PL- Consultation- Private Sector Housing (EH) response

Subject: RE: Planning Consultation on: BR/2/26/PL

Application No: BR/2/26/PL
Registered: 16th February 2026
Site Address: 37 Glamis Street Bognor Regis PO21 1DJ
Grid Reference: 493728 99312
Description of Works: Conversion existing dwelling into 6 bedroom, 10 person HMO. This application is in CIL Zone 4 (Zero Rated) as other development.

SITE
37 Glamis Street, Bognor Regis, PO21 1DJ
DRAWING TITLE
Proposed Floor Plans

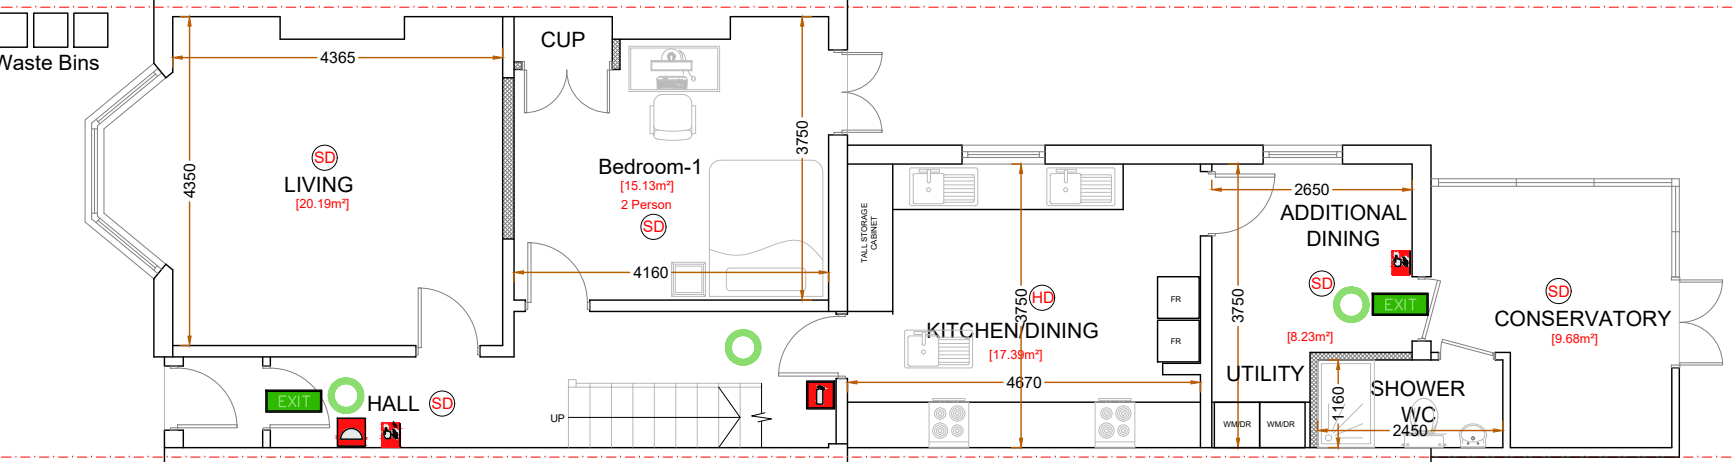
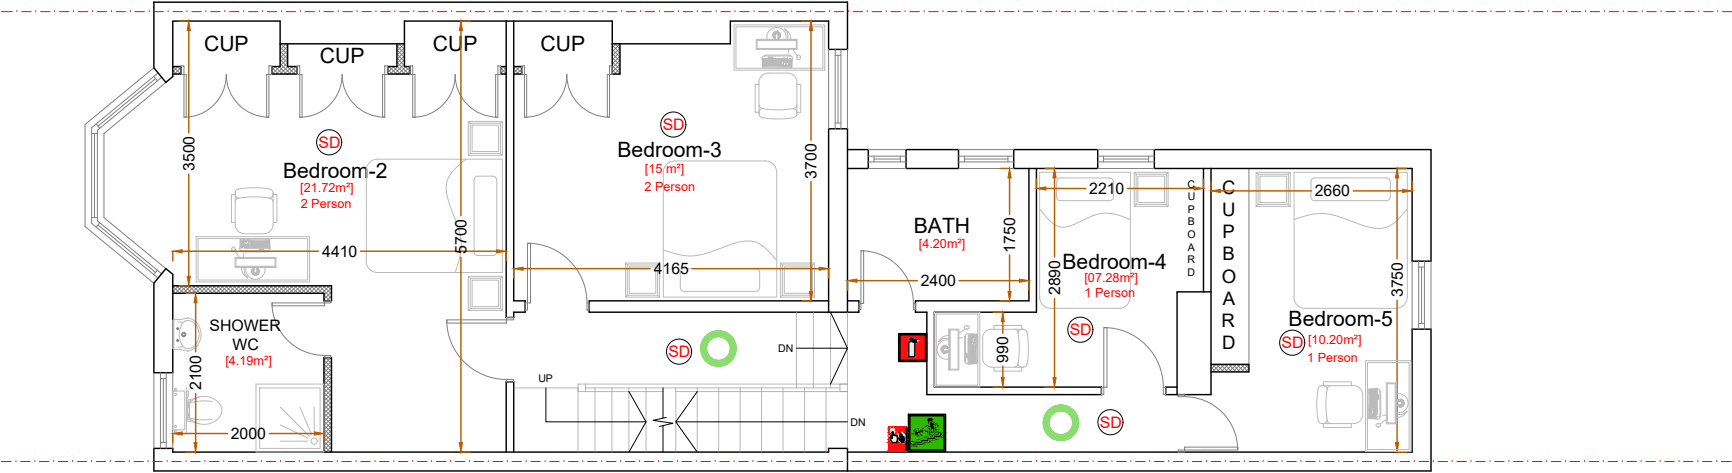
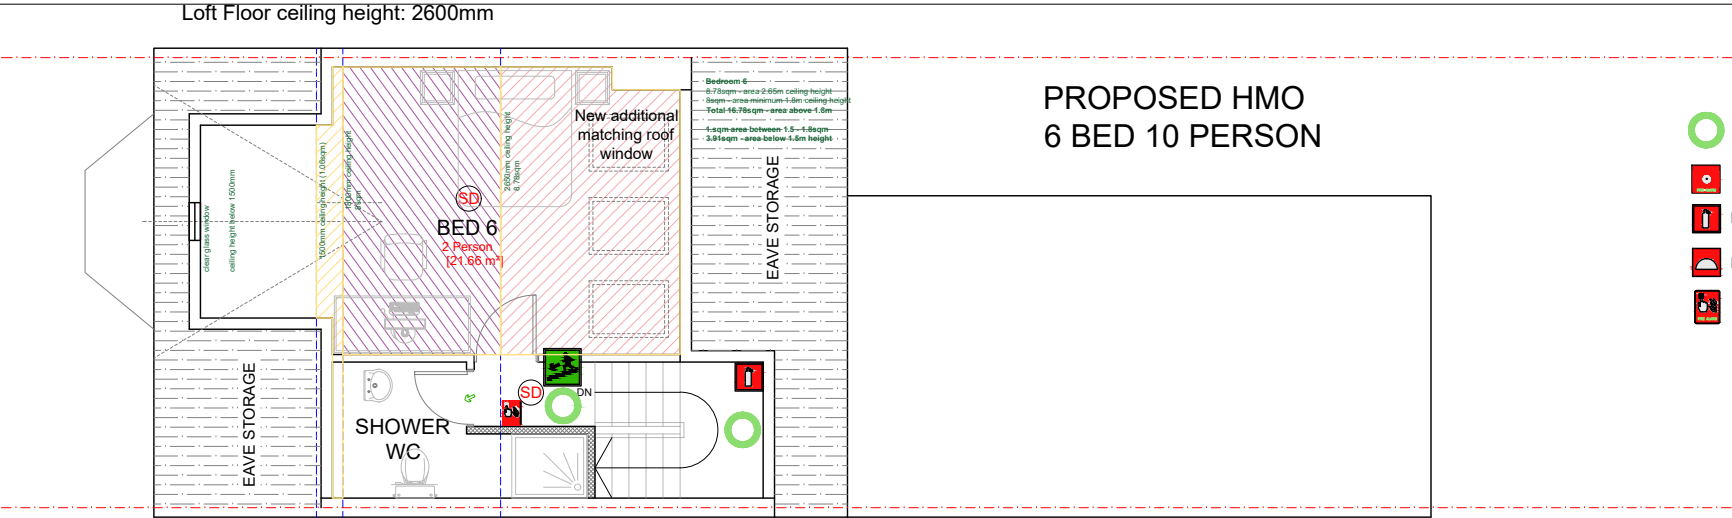
- An additional interlinked smoke detector is required in the ground floor entrance lobby. It is acknowledged from the “Fire Safety Strategy” that the fire alarm system is intended to be Grade A, LD2.

- The proposed layout of the kitchen appears to show insufficient worktop space for 10 occupants. A minimum of 500mm (L) x 600mm (D) is required per person (smaller lengths of less than 500mm cannot be counted towards the overall requirement). Looking at the proposed plans this could potentially be achieved by relocating the two fridge freezers into the additional dining area and fitting additional worktop space along that wall. In addition, the tall storage cabinet could also be removed and replaced with additional worktop with cupboards sited above and below (please be aware there should also be one storage cupboard available per person (not including the space below any sink), please refer to Arun’s HMO standards for cupboard measurements). If relocating appliances within the additional dining area, consideration should be given to removing the door between the kitchen and dining area so that it has an “open-plan” feel and would make it easier for occupants carrying fridge items into the main kitchen area.

- The proposed ground floor bathroom is accessed via the conservatory which is inappropriate. This bathroom will need to be reconfigured so that it is accessed via the additional dining area, instead.
- In addition, the ground floor bathroom does not appear to be of an appropriate size/layout to provide adequate changing and drying space for the users. From the proposed plans,

the bathroom appears narrow and compact, increasing the likelihood that the users would potentially collide with their surroundings (e.g. the walls and/or the amenities). The Licensing and Management of Houses in Multiple Occupation and Other Houses (Miscellaneous Provisions) (England) Regulations 2006 specifies that all bathrooms must be of an adequate size and layout, which is also echoed within Arun's HMO standards. In addition, this could be identified as a hazard under the Housing Health and Safety Rating System (HHSRS). Therefore, consideration should be given to reconfiguring and/or increasing the width of this bathroom.

- Kitchens and bathrooms/shower rooms/ensuites should have adequate mechanical extraction in addition to any windows.
- The double doors within bedroom 1 provide the only means of ventilation within the room. French or patio doors as the only source of ventilation within a bedroom is not acceptable and all bedrooms must be provided with adequate openable window casements that allow for appropriate ventilation, equivalent to 1/20th of the floor area.
- If roof windows are the only source of light and/or ventilation within bedroom 6 (which is likely to be considered the case given the location and size of the window to the front elevation) they must meet all of the requirements outlined within Arun's HMO standards.
